**Responses to the ExA's Written Questions**  
**ELMESTHORPE PARISH COUNCIL**  
**9<sup>th</sup> January 2024**

Please find below Elmesthorpe Parish Council's responses and/or notes with regard to the Written Questions issued by the Examining Authority on 28<sup>th</sup> November 2023.

#### **1.11.32 Effect on users of Burbage Common Road**

Note: To be read in conjunction with the Access and Rights of Way Plans (document reference: APP-017 to APP-020) and the Public Right of Way Appraisal and Strategy (document reference: 6.2.11.2)

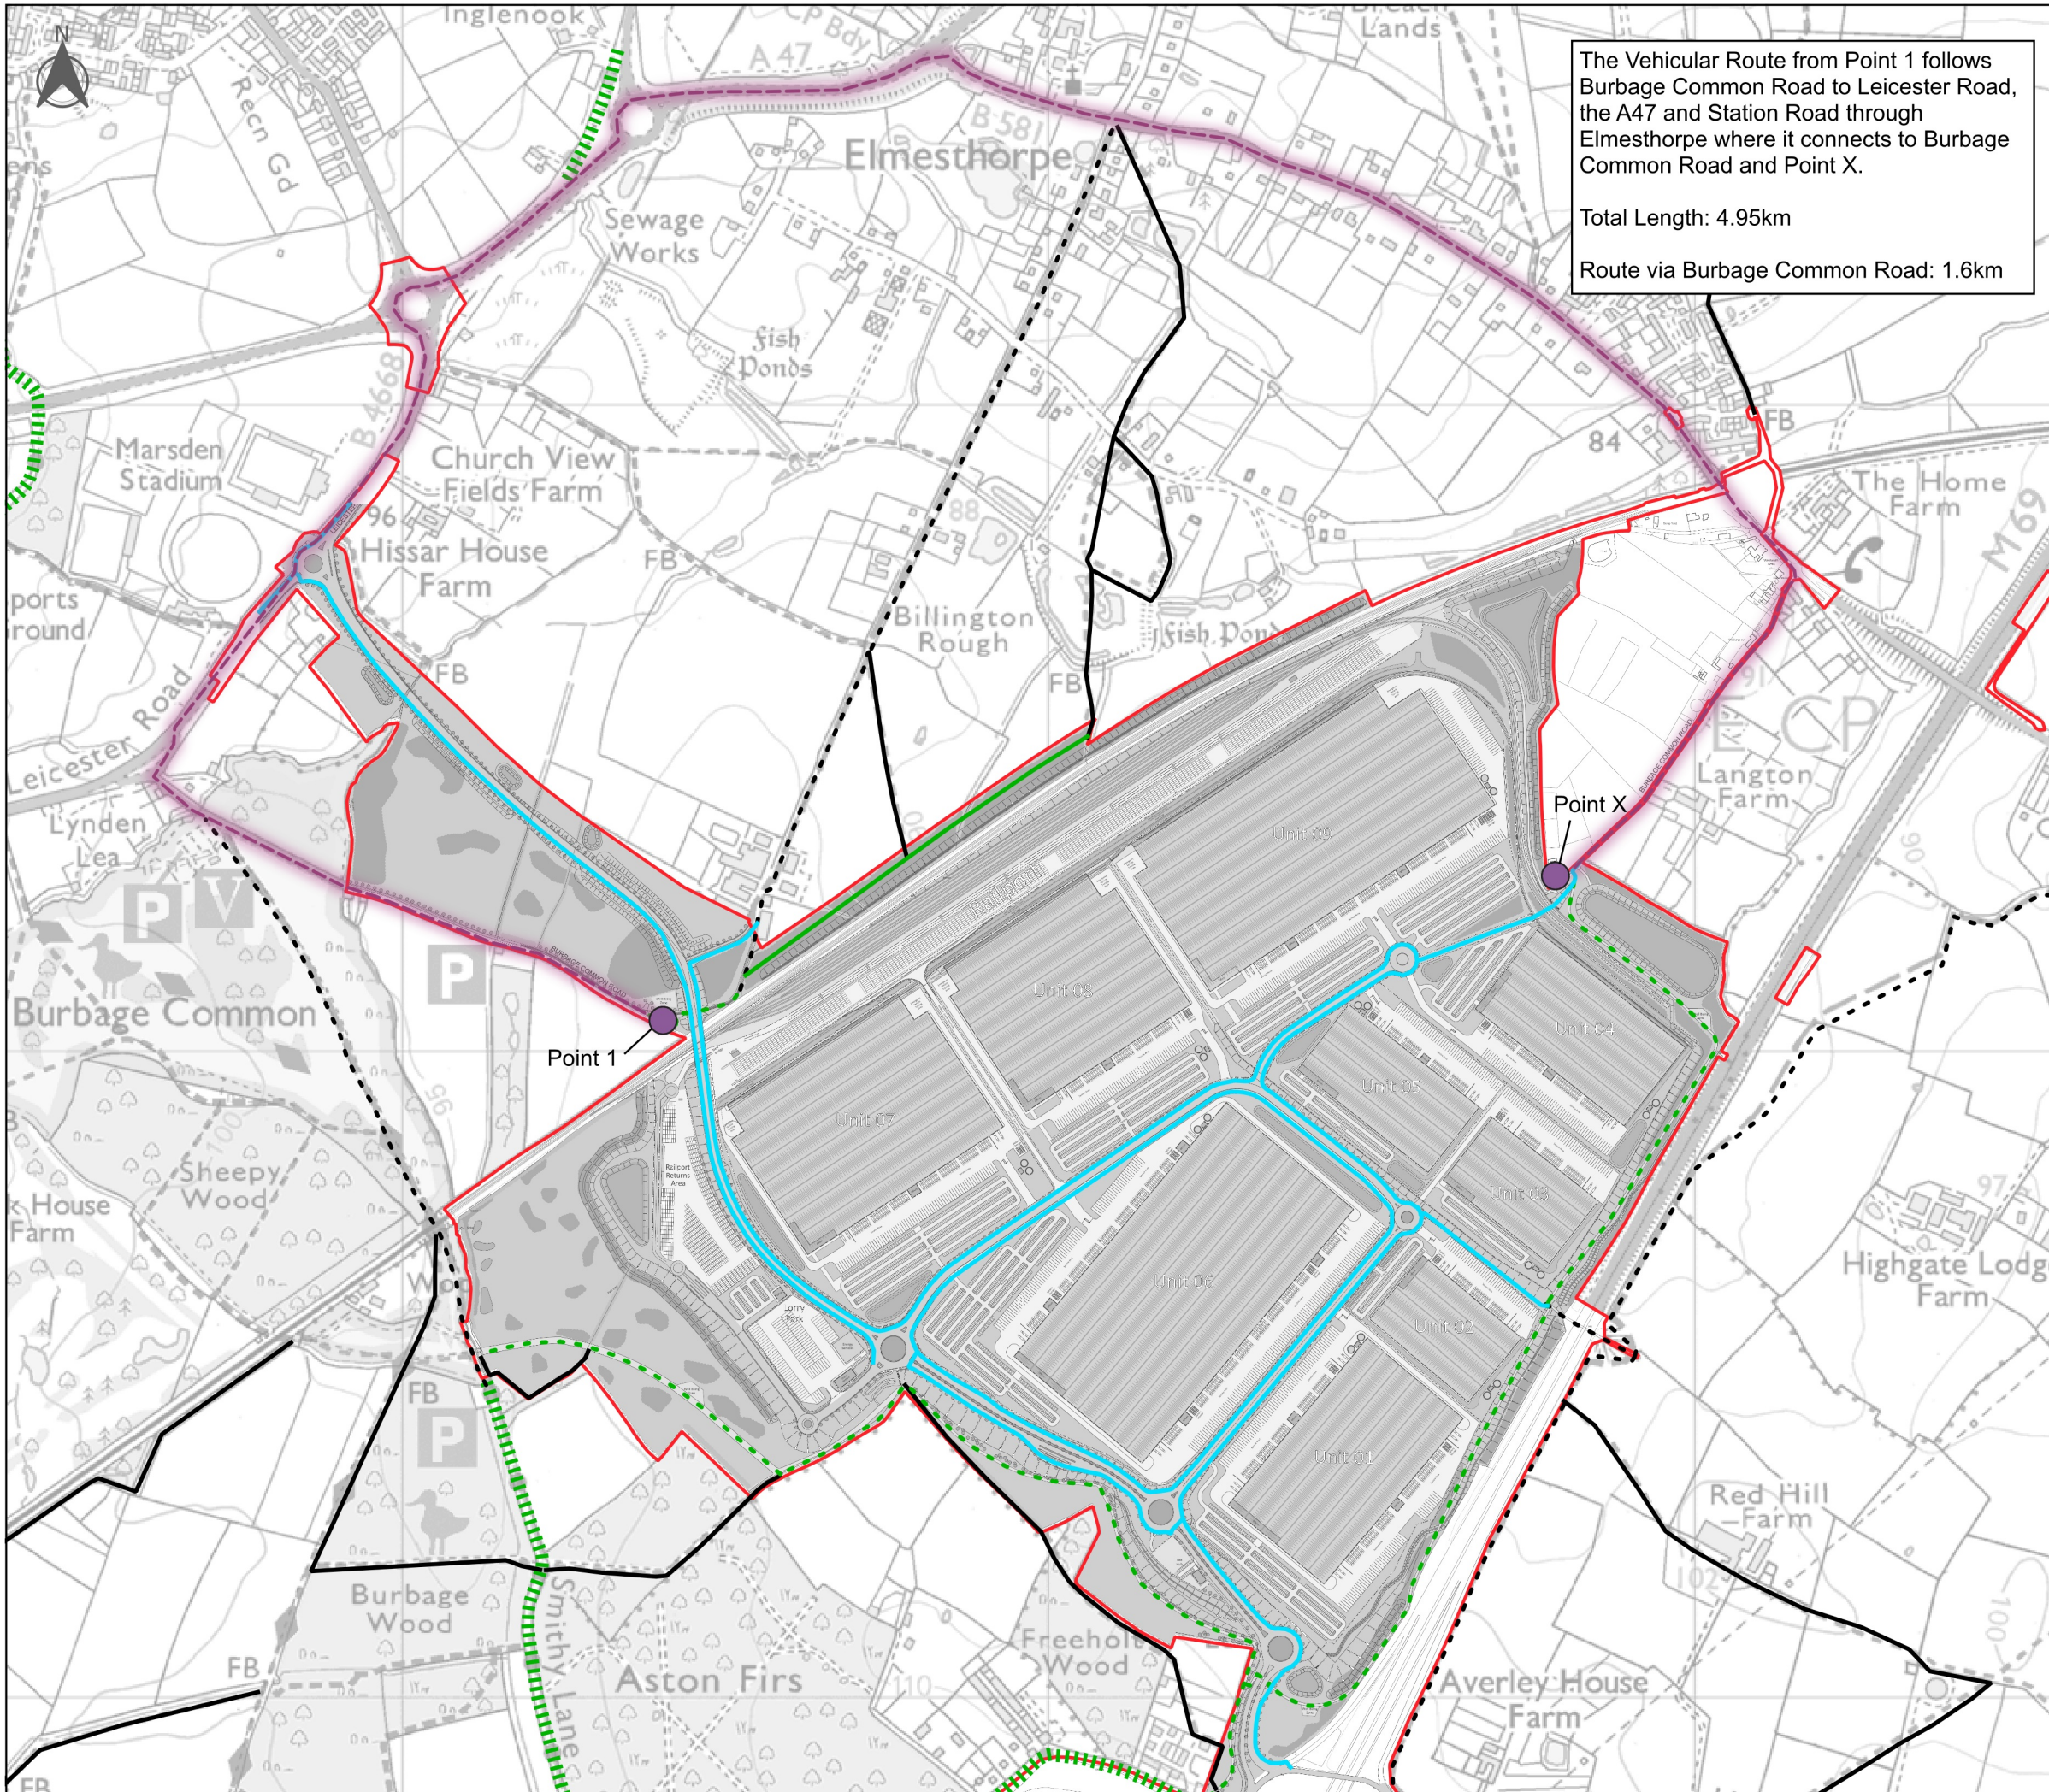
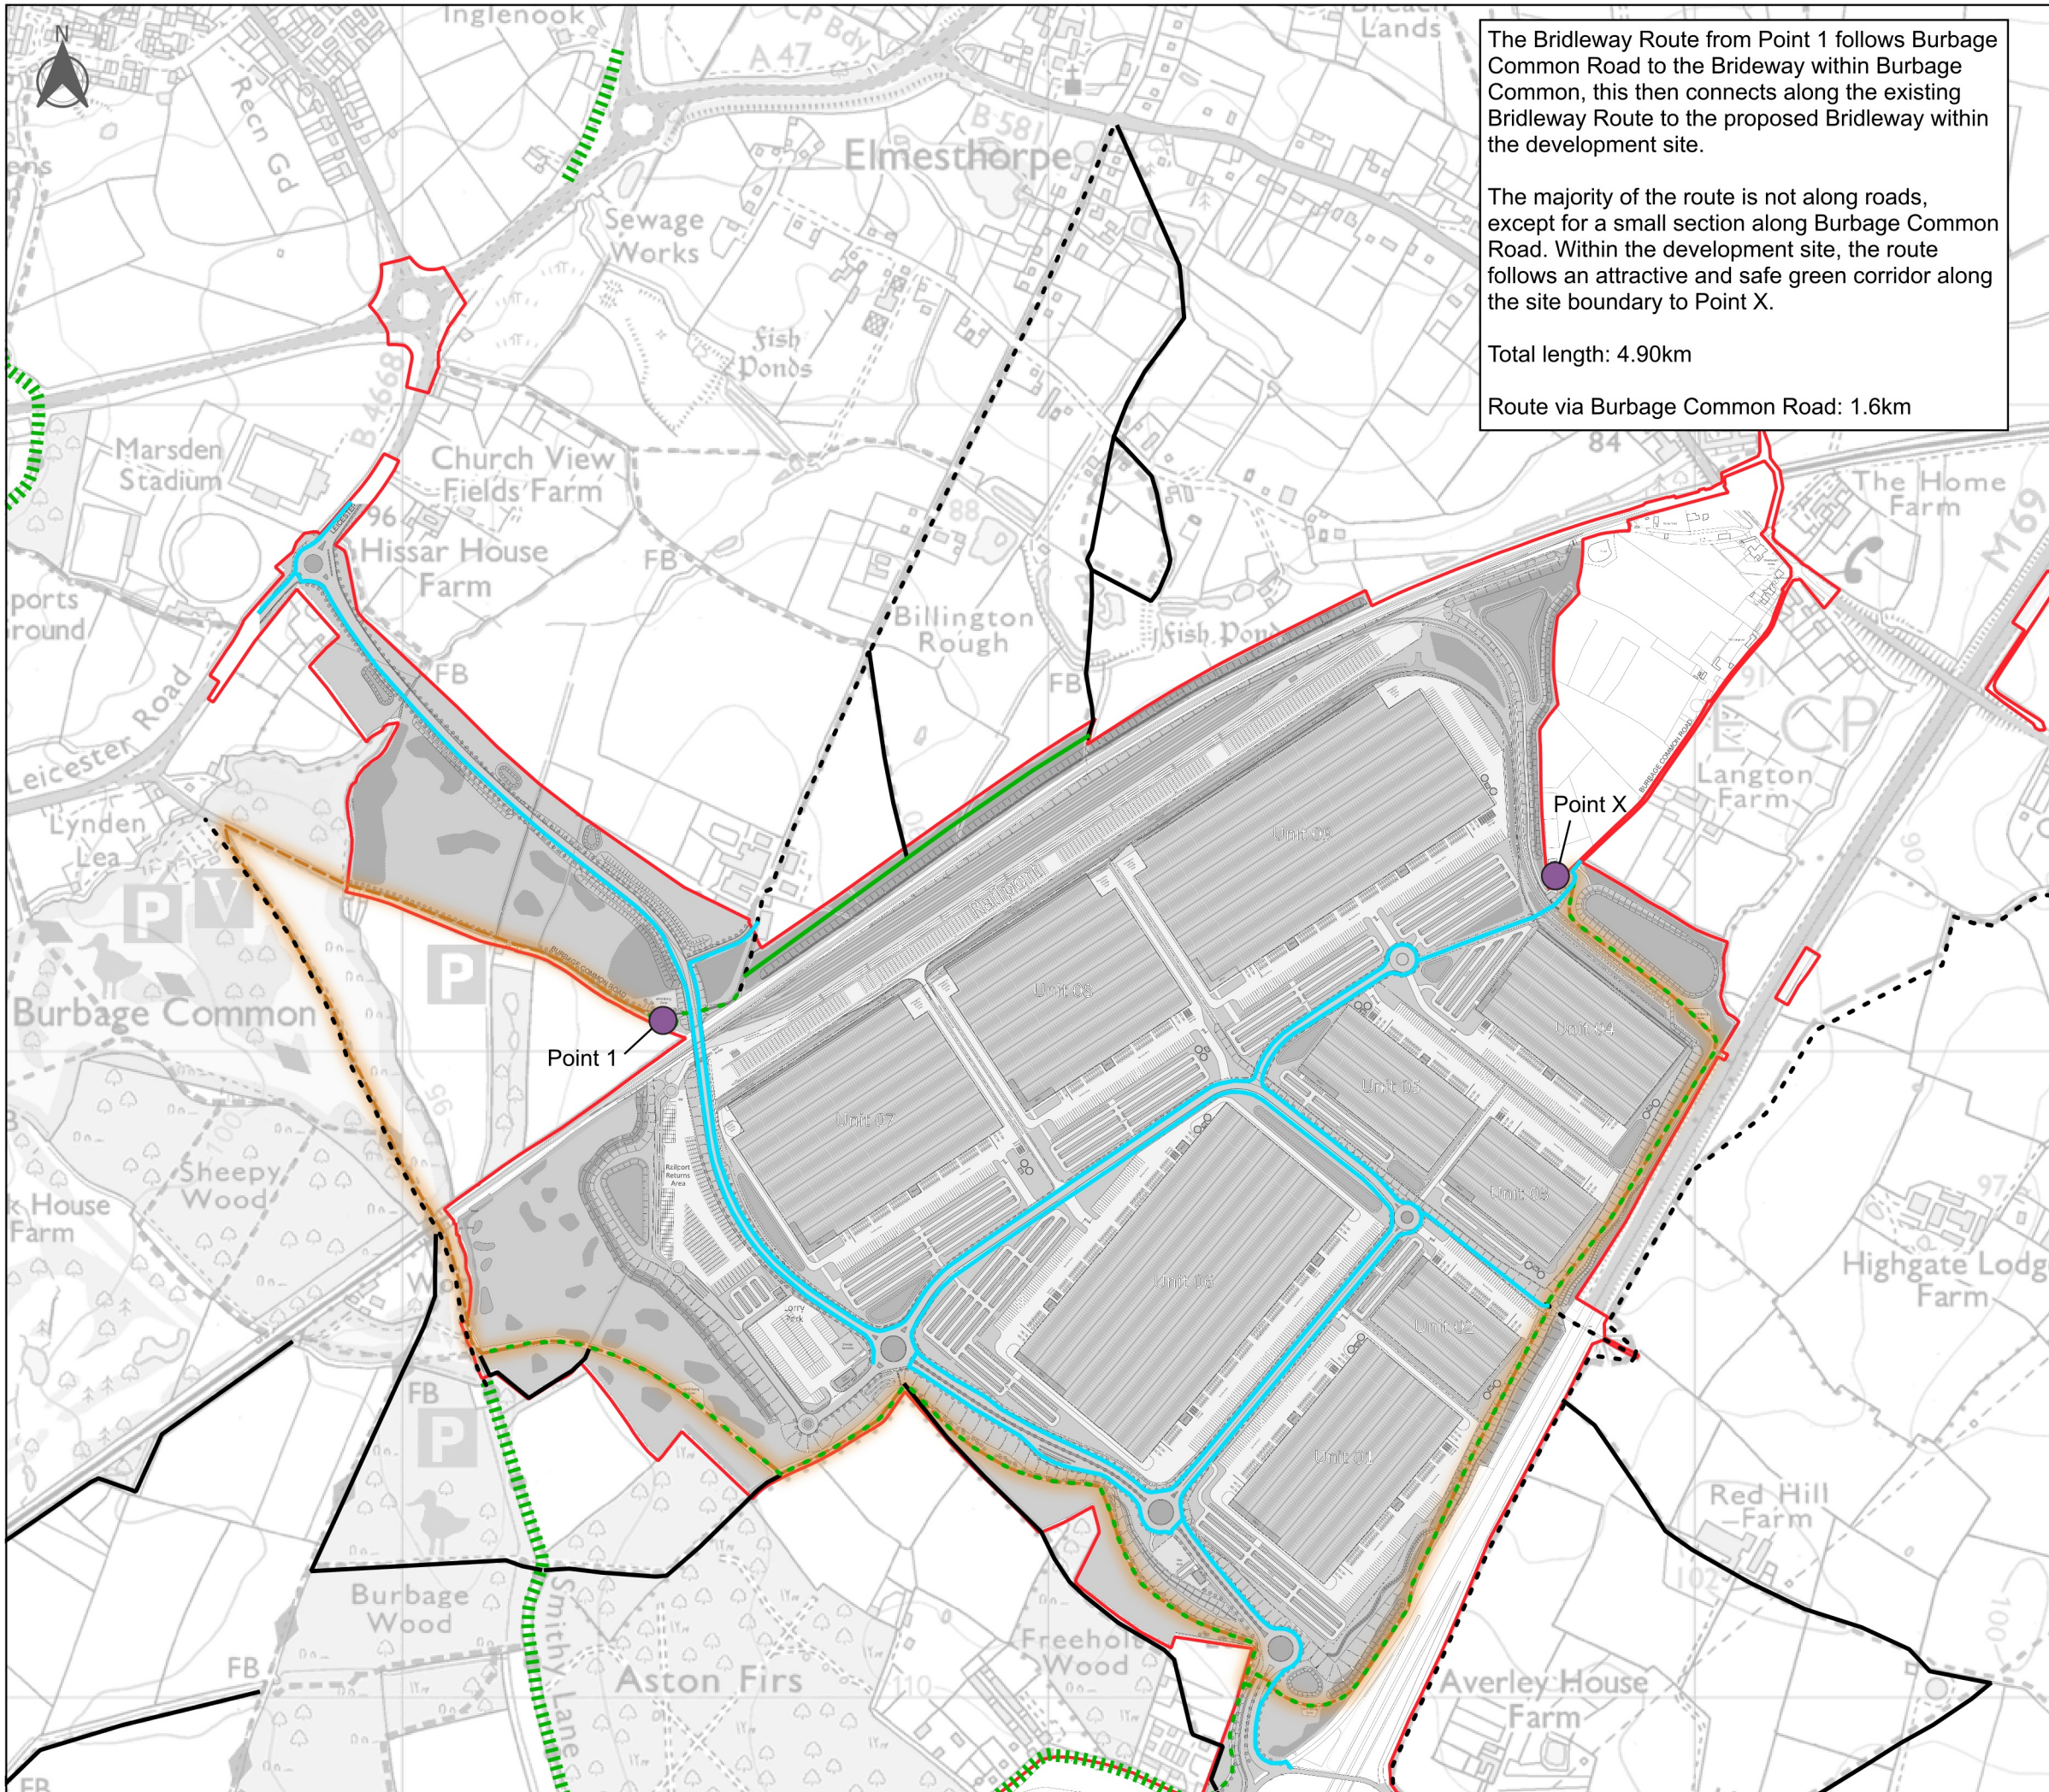
When looking at the distances between point 1 and X on the 'Accessibility Plans for Burbage Common Road', we submit:

Vehicle Users; the current 1.6km route will increase to 4.95km. Our only alternative vehicular access into the village will be entirely removed and any incidents that prevent access from either end of Station Road B581 will severely affect residents and emergency services, and the only available detour will be significant. Add into this the substantial increase in traffic using and joining the B4668 and A47 as a result of the A47 Link road, and the cumulative effect on residents trying to go about their daily lives will be extensive.

Cyclists; The roads surrounding the proposed site are narrow, fast, dangerous and undesirable. Will there be lighting available during the winter months, for those commuting to work (potentially both on and off site) using the revised PRow offered? If so, have the effects of this been considered in the assessments of the impact of lighting on ecology, local residents, energy usage etc? What security will be in place to ensure safety at the newly installed underpasses? Cyclists travelling through the site from Elmesthorpe will not be exiting onto the M69 and therefore will be joining the main carriageway at the roundabout where the A47 link road meets the B4668. What provisions will be made to protect cyclists at this busy junction, mainly occupied by HGVs?

Bridleway Users: the current 1.6km route will increase to 4.95km. Aside from the substantial increase in distance which not only will tire the horse out before they even reach their destination; the additional time implications involved in this impacts the frequency that equestrian users may be able to hack in their own locality. This is removing a key benefit and reason that many equestrian business and private owners chose to base themselves here for. It goes without saying that the amenity of the new bridlepath provided is no substitute for the environment currently experienced.

Walkers: It is firstly considered the user group merely identified as 'Walkers' is a very broad group and doesn't identify the many different types of users who use this area as pedestrians. That aside, walkers who use the current 1.6km PRow route experience a wide, level, quiet road that serves more as a path enjoyed by all types of people and animals, with immediate access to the amenity of surrounding countryside. It does not discriminate against any groups whom fall within the groups identified with Protected Characteristics and provides unimpeded access for all, should they choose. All of the proposed alternative PRows for pedestrians provide increased distances (the shortest increase being a full 50% increase) which will serve to alienate and exclude some users, including (but not limited to) those who currently walk with young children to utilise the newly upgraded children's play area at Burbage Common or those with mobility issues. All of the proposed alternative routes offer reduced amenity and experience to the current PRow and nobody would choose to simply take a shorter leisurely amble around a SRFI before returning home due to personal limitations. The increase in route distances, and the stark reduction in amenity value would entirely remove the access to countryside for some users.
